Application number: 2023/93076	
What is the application for?:	External alterations to former bank building to form restaurant and takeaway, in
Address of the site or building:	former Lloyds Bank, 22, Carr Lane, Slaithwaite, Huddersfield, HD7 5AN
Postcode:	HD7 5UT

Type of comment: An objection	
Do you wish your comments to be published on the website anonymously?	Yes

Drawing Proposed Site Plan	Scale @ A1 1:200
-------------------------------	---------------------

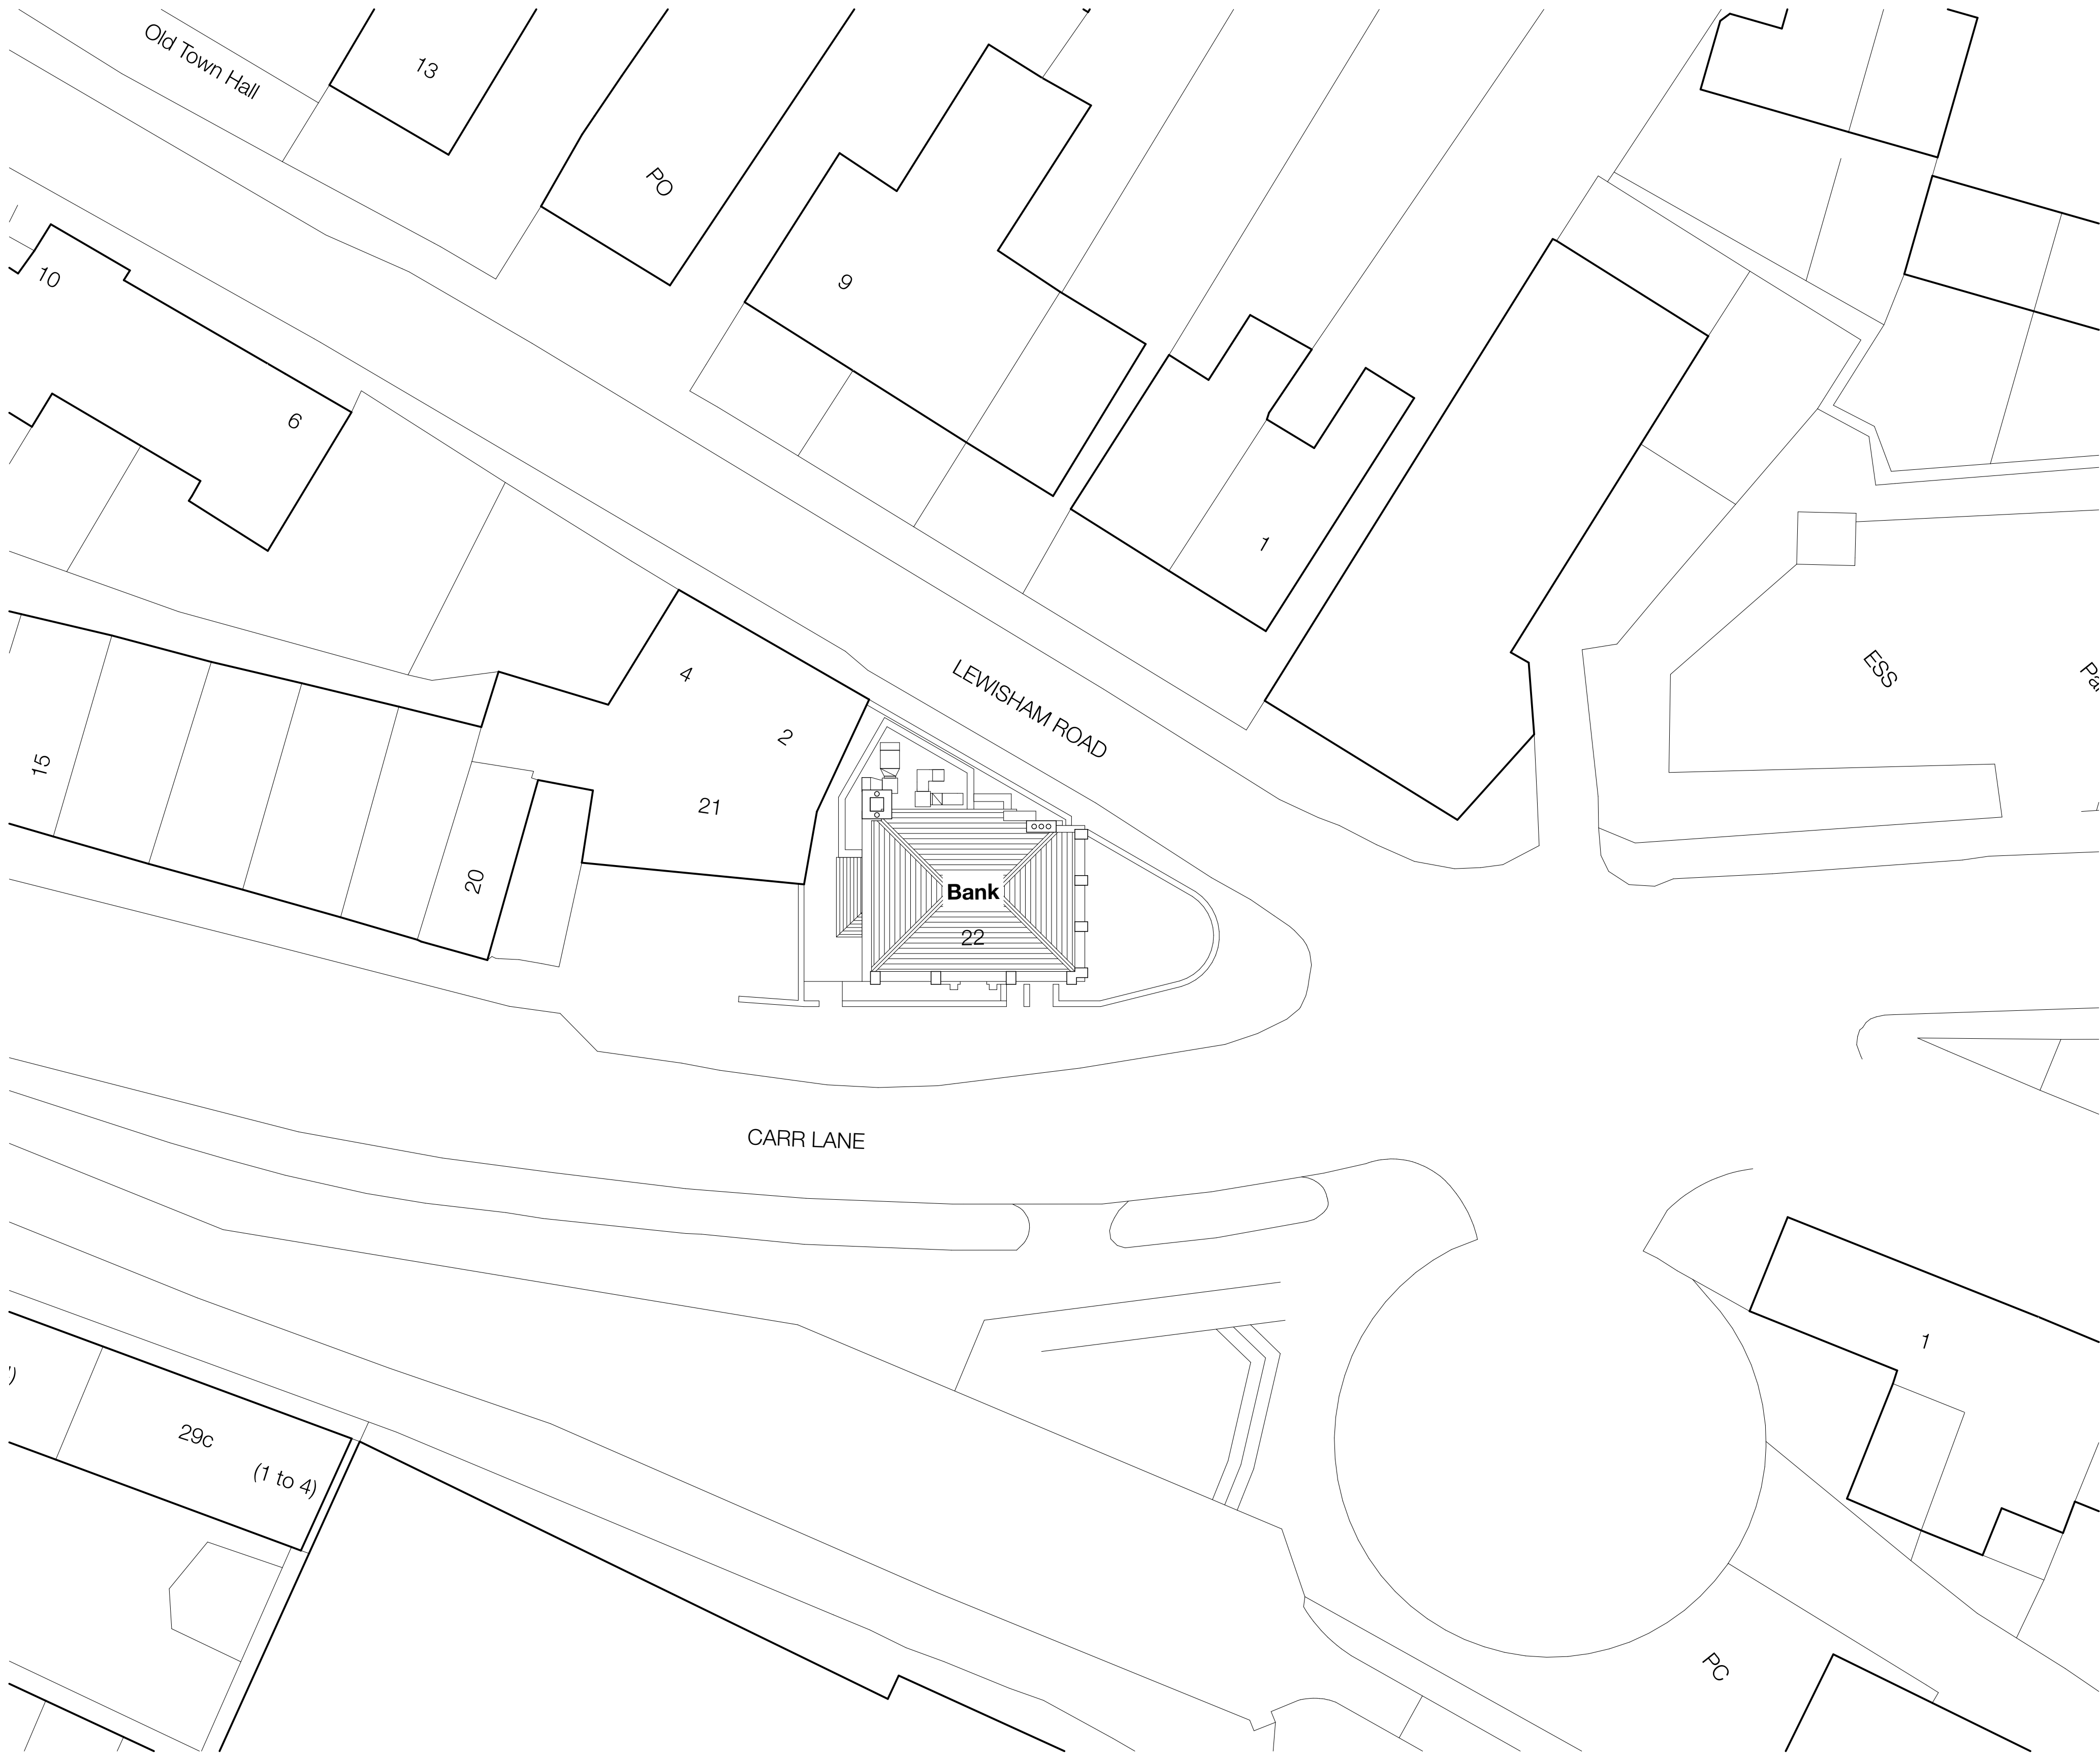
The proposed outdoor seating area already has established trees and hedges- will these be able to be preserved whilst still accommodating all the proposed outdoor seating?

The bins at the existing Rumpus on Church Street are large, always full, and sometimes over flowing. The new proposed restaurant will be bigger, but there seems to be even less space allocated for the bins to go. Over flowing rubbish will be unsightly, smelly and attract vermin to both Lewisham Road and Carr Lane.

Drawing Proposed Roof Plan	Scale @ A1 1:50
-------------------------------	--------------------

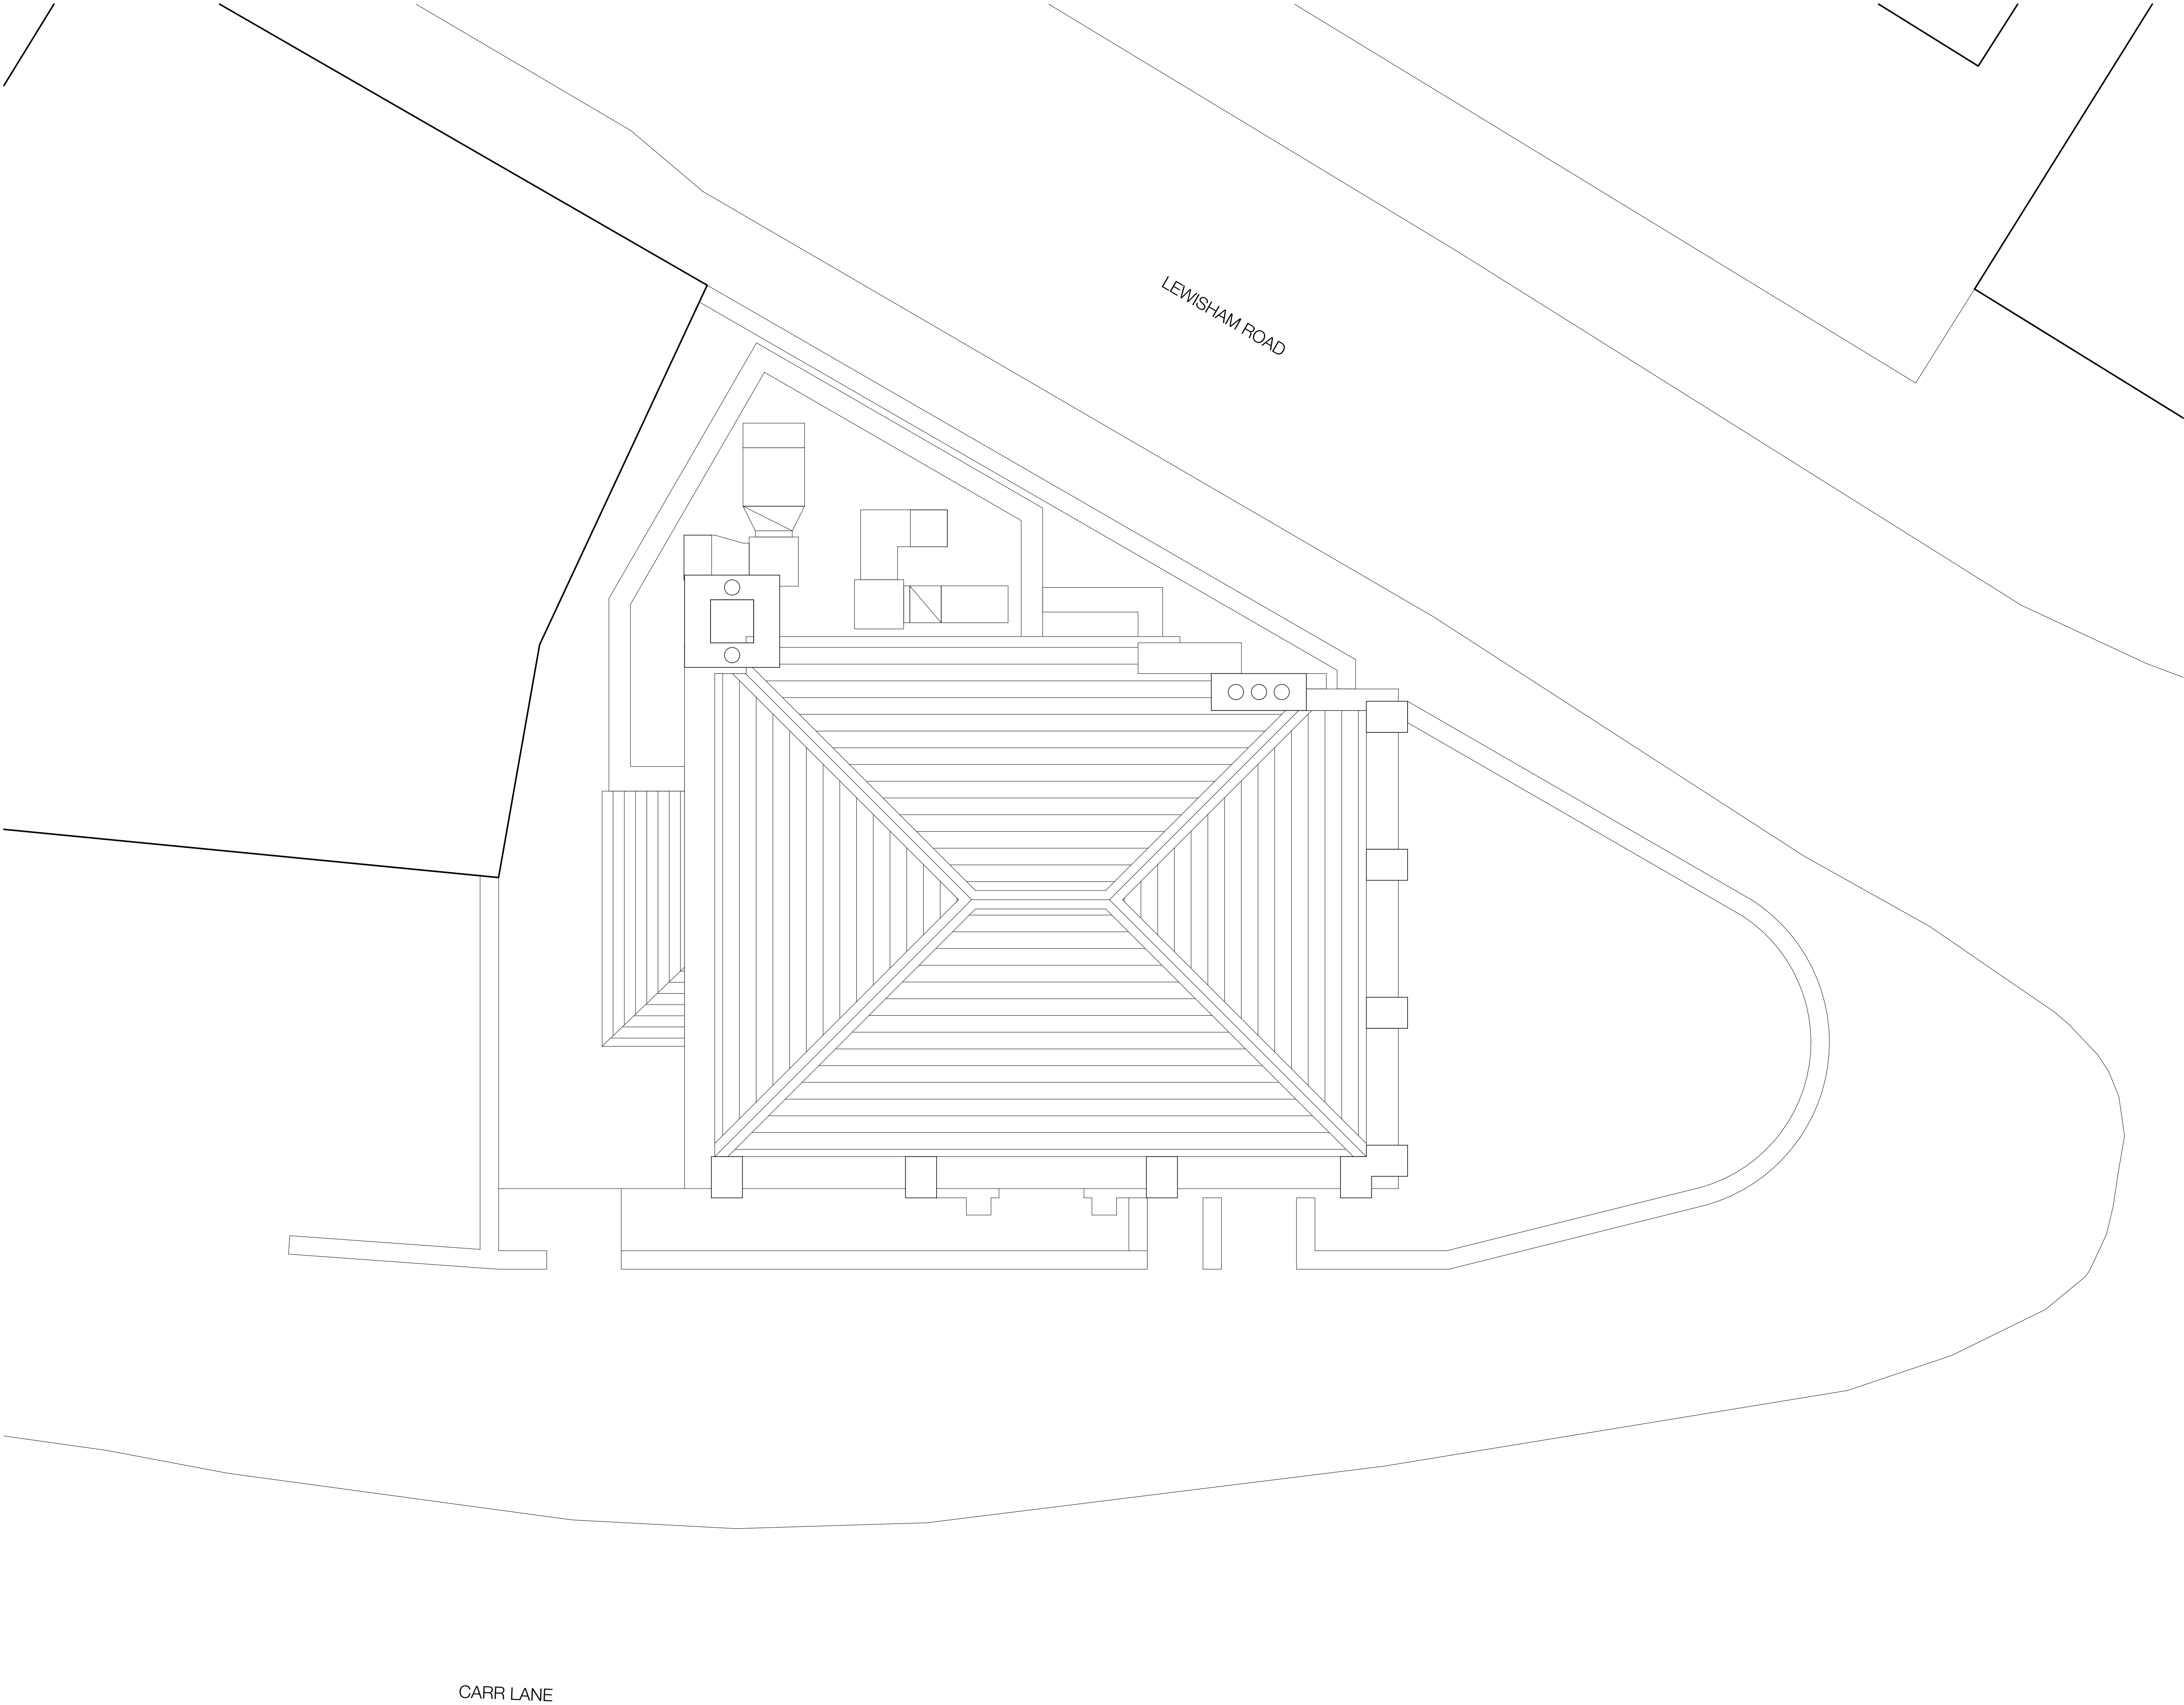
Having witnessed the strong odours and thick smoke created from the exiting Rumpus on Church Street, I am very concerned the noise and smell from the extraction unit- which is proposed to be right opposite our house- will adversely affect the whole street and blow directly into our property. Even with the proposed back wall height increase, the extraction will still be lower than all the properties around the old bank- and directly level with our ground floor- and the extraction unit will be clearly visible from our bedroom window.

Also, where will any refrigeration or air conditioning plants be situated? And how will they visually affect our conservation area and will they be noisy?
